# WAMBO COAL PTY LTD

## NORTH WAMBO UNDERGROUND MINE MODIFICATION

### RESPONSE TO SUBMISSIONS

FOR THE MODIFICATION OF DA 305-7-2003 (MOD 13)  
THE ADDITION OF NORTH WAMBO UNDERGROUND MINE  
LONGWALLS 9 AND 10

**Figure 5 – Major surface water drainage systems and extent of associated alluvium**

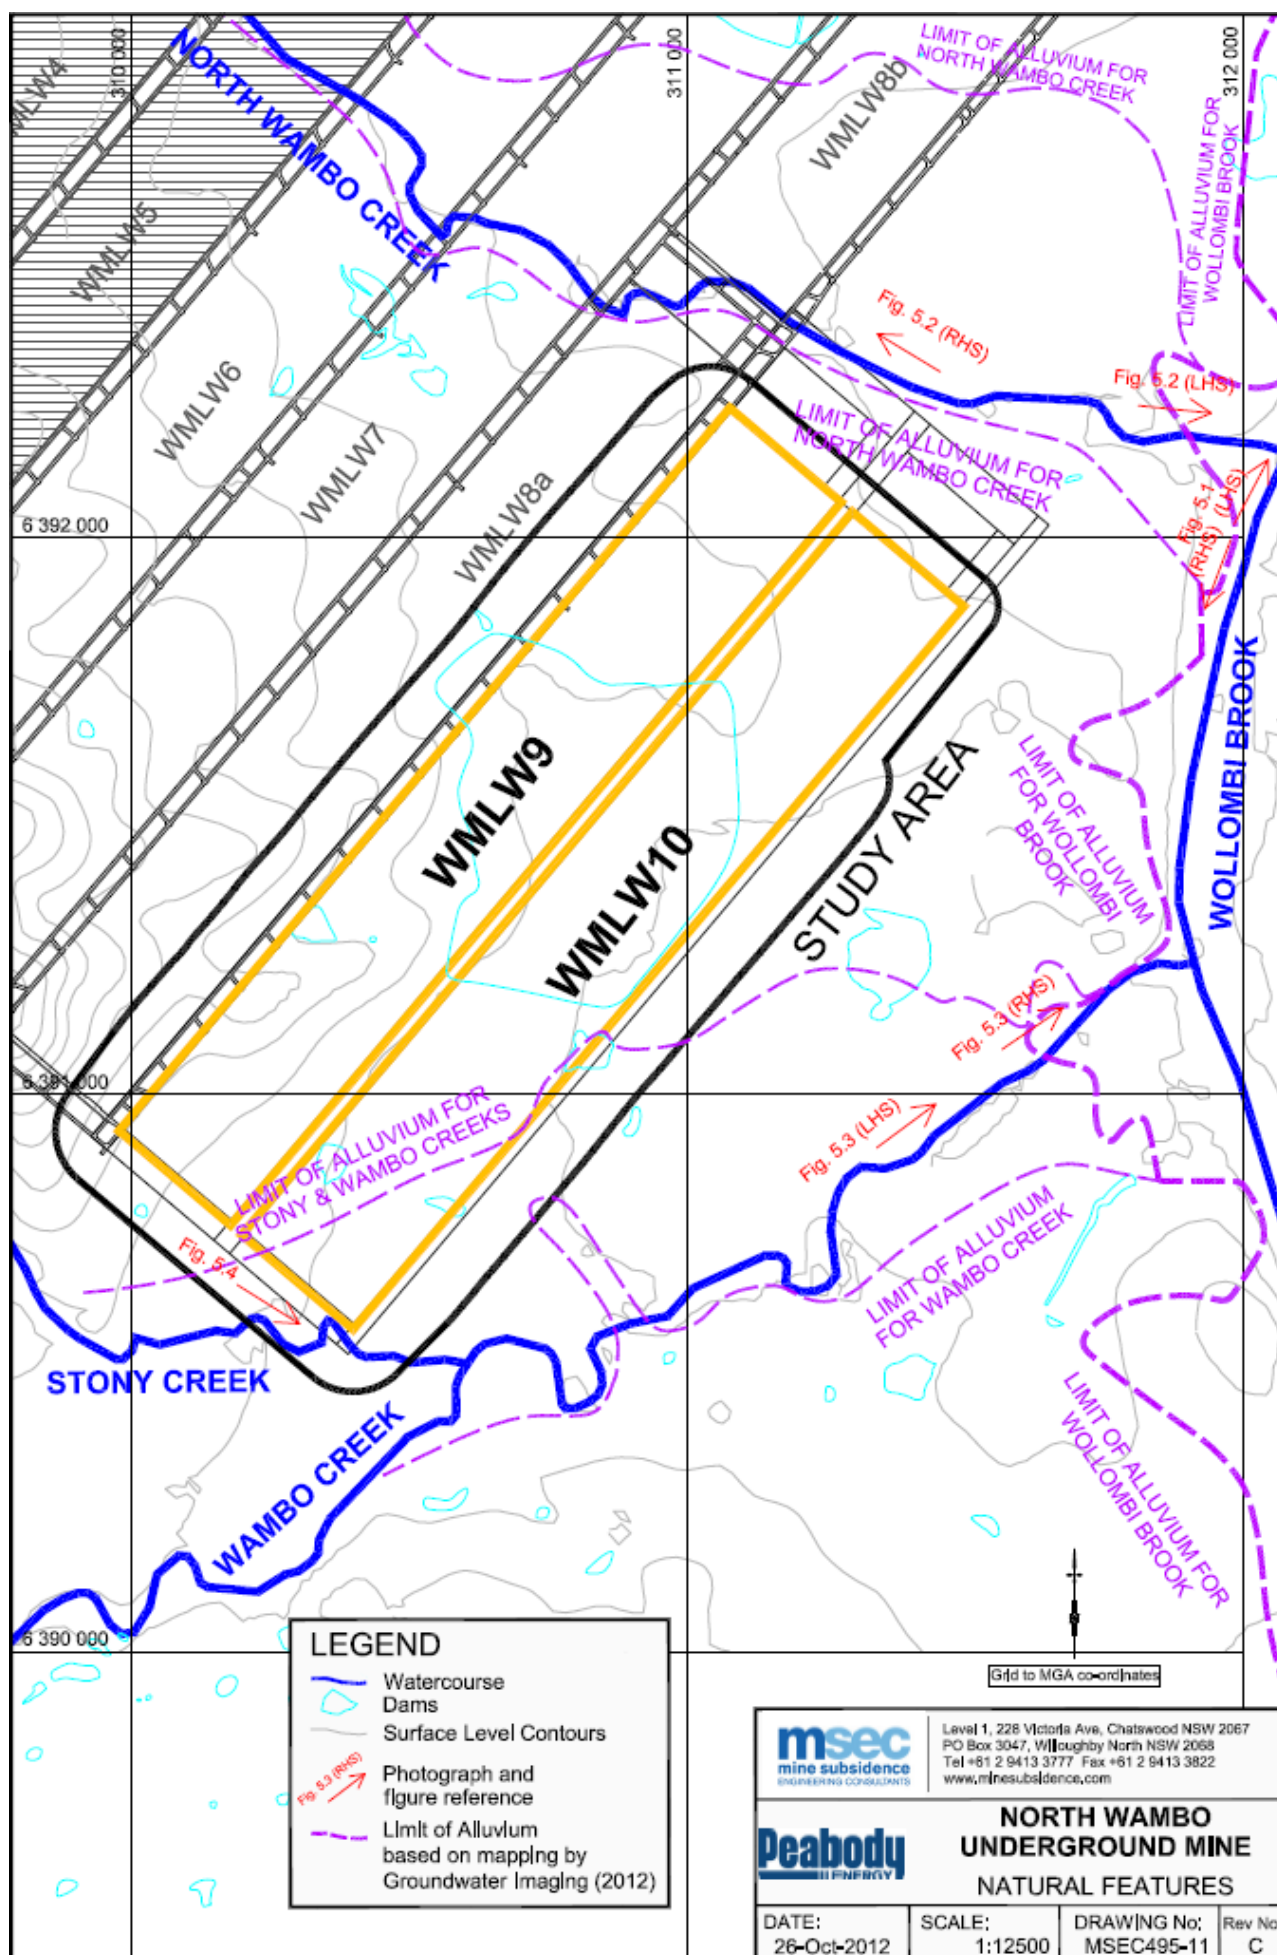
Mr R Fenwick	Raised concerns that the mapped alluvial extent in Figure 8 of the EA was incomplete and inadequate.	<p>Dr David Allen at Groundwater Imaging Pty Ltd (2012) conducted a transient electromagnetic survey of the extent of the Wollombi Brook alluvium. A transient electromagnetic survey uses electrical current to measure the electrical resistivity of the shallow stratigraphic profile. The data is collected by a towed transient electromagnetic device and is limited by access constraints (e.g. the survey cannot be conducted through dense vegetation).</p> <p>The alluvial boundary determined by the transient electromagnetic survey was interpreted with reference to bore logs and field observations and is largely consistent with the regional geological mapping.</p> <p>The results of the transient electromagnetic survey are considered in conjunction with regional geological mapping where access constraints limited site-specific collection of data.</p>
